S. LLEWELLYN & ASSOCIATES LIMITED  
CONSULTING ENGINEERS

March 6, 2019

**RE: 3598 Innes Road (D07-12-18-0132)**  
**Ottawa, ON**

Thank you for your comments in connection with the above noted project in regards to the review of the submitted engineering plans. We have had the opportunity to review your comments and offer the following response:

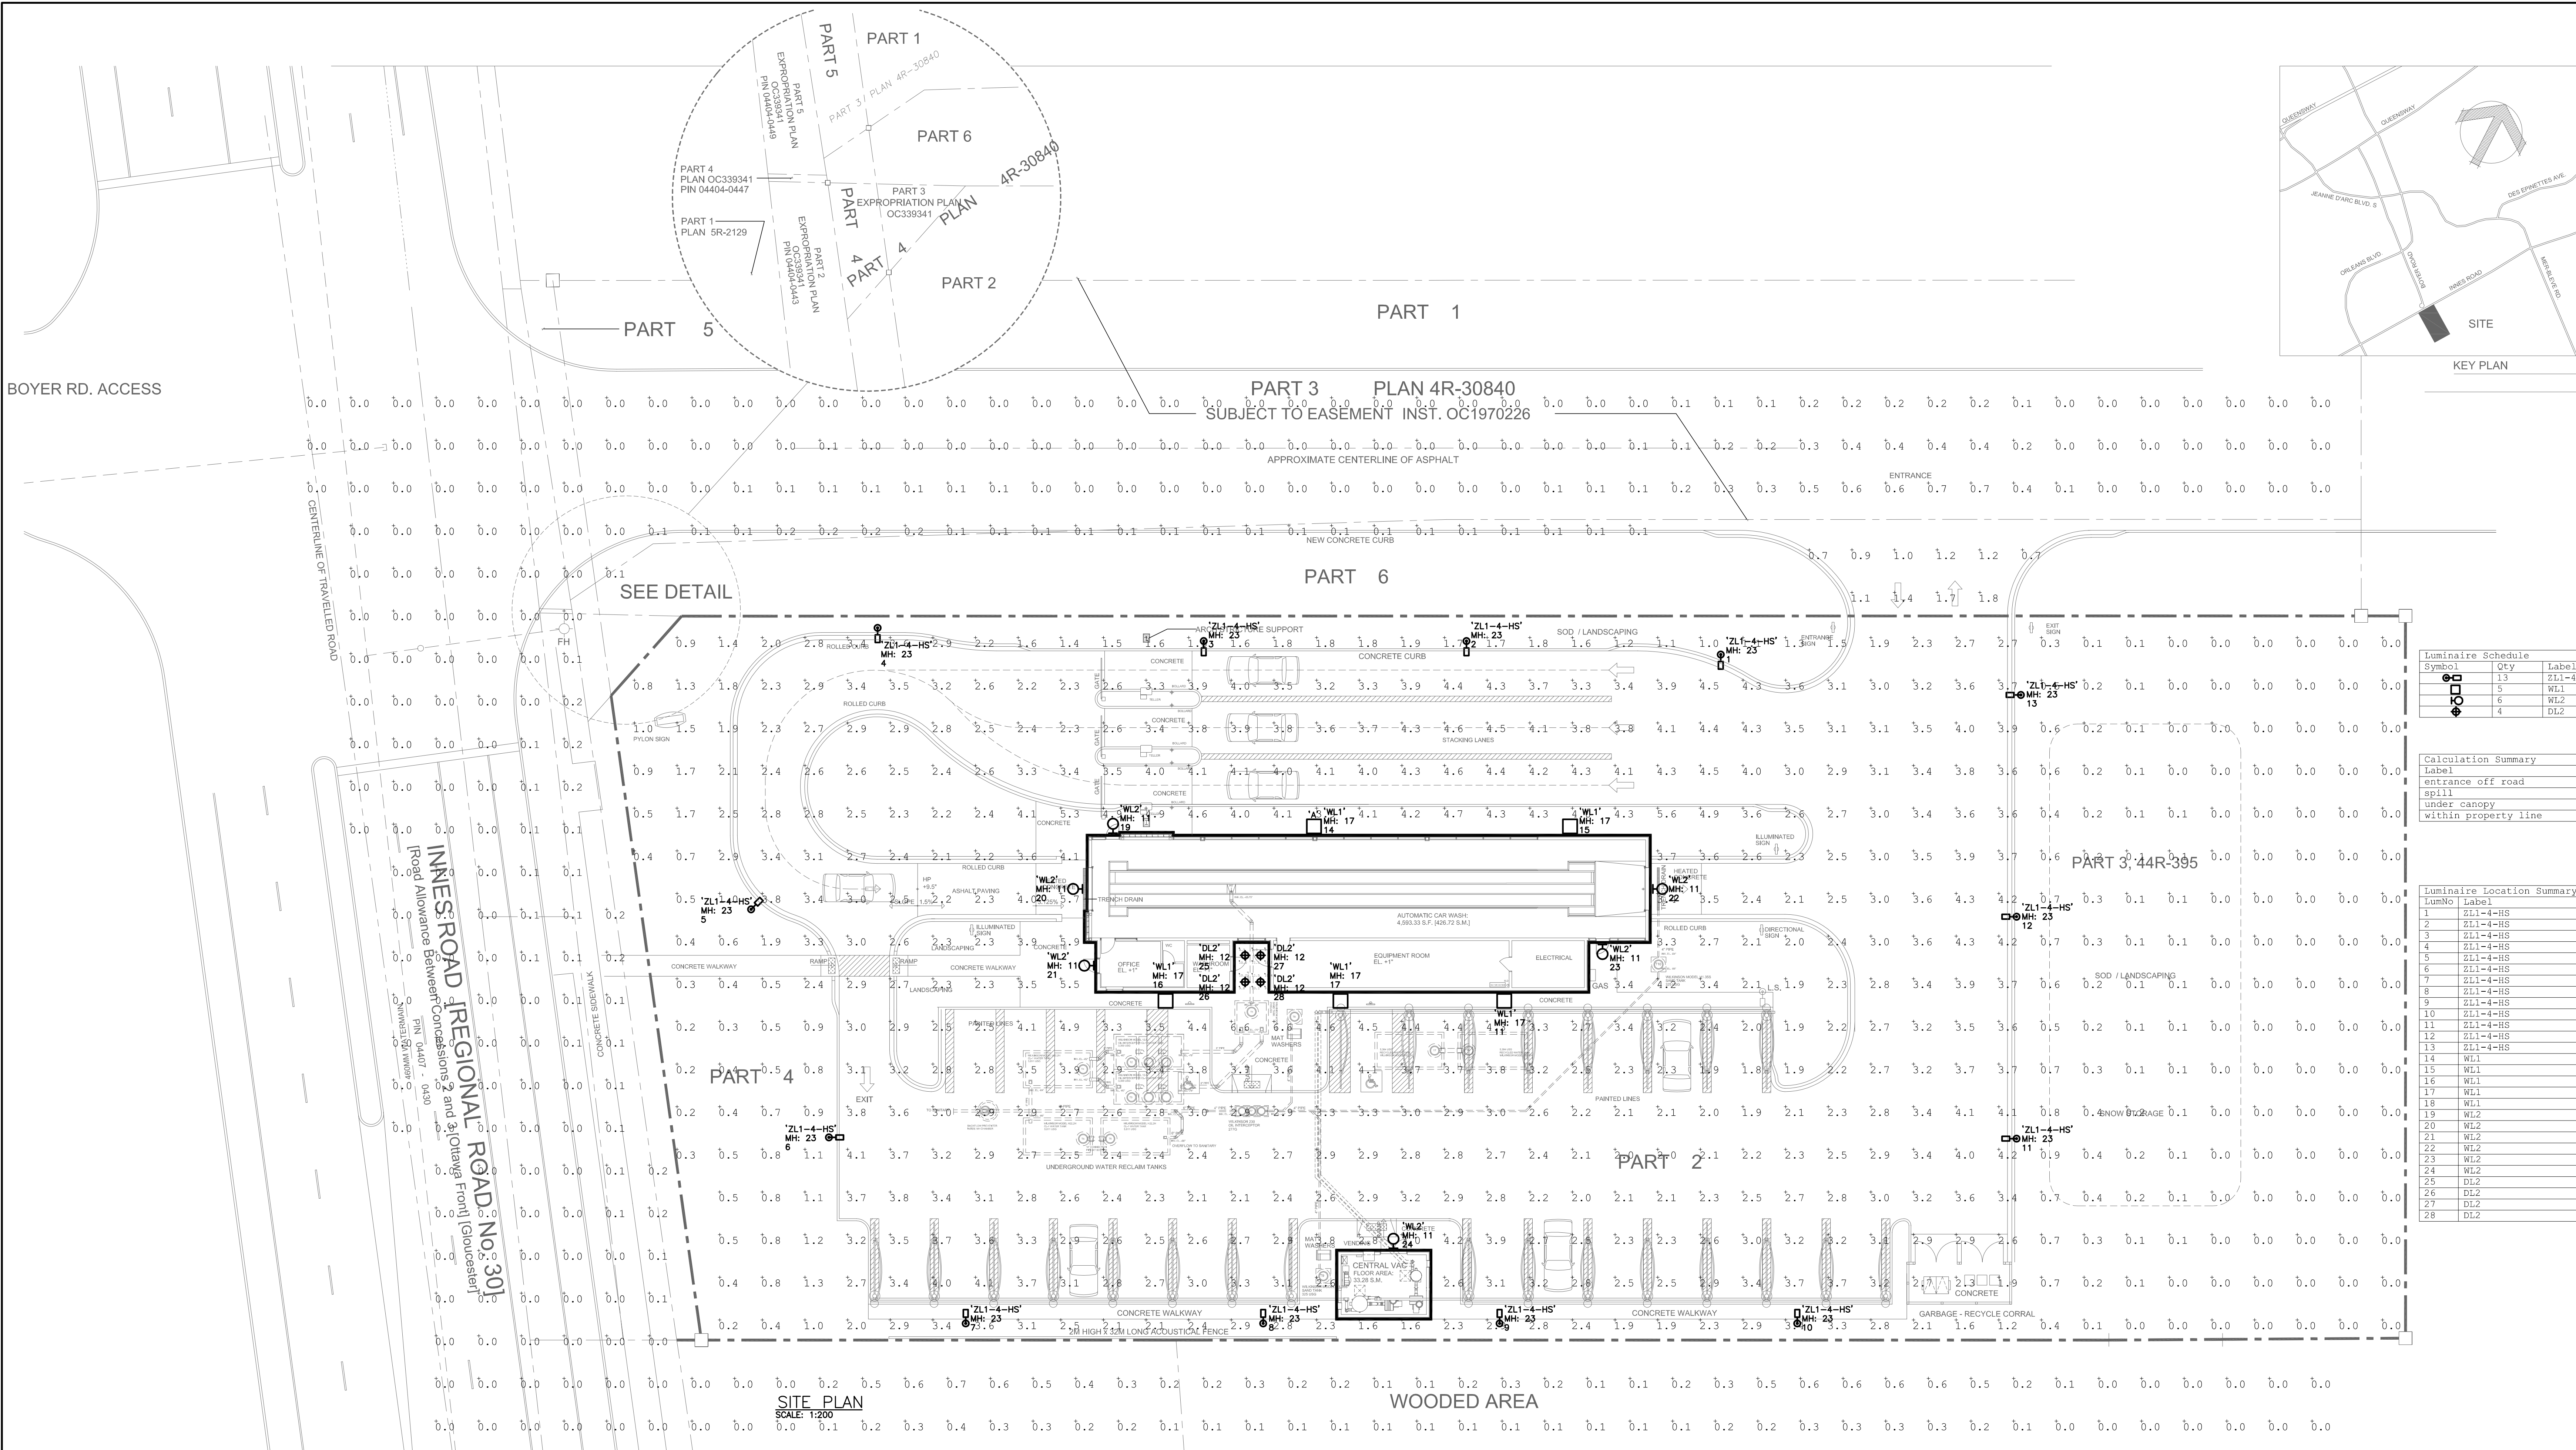
- A2. *Please provide a site lighting certificate, sealed by a P.Eng., that satisfies the following condition:*

*Prior to the Site Plan Approval, the applicant shall provide a certificate, from an acceptable professional engineer, that the site lighting has been designed to meet the following criteria:*

- a) *It must be designed using only fixtures that meet the criteria for Full Cut-Off (Sharp cut-off) Classification, as recognized by the Illuminating Engineering Society of North America (IESNA or IES), and;*
- b) *It must result in minimal light spillage onto adjacent properties. As a guideline, 0.5 fc is normally the maximum allowable spillage.*

**Please refer to the lighting plan.**
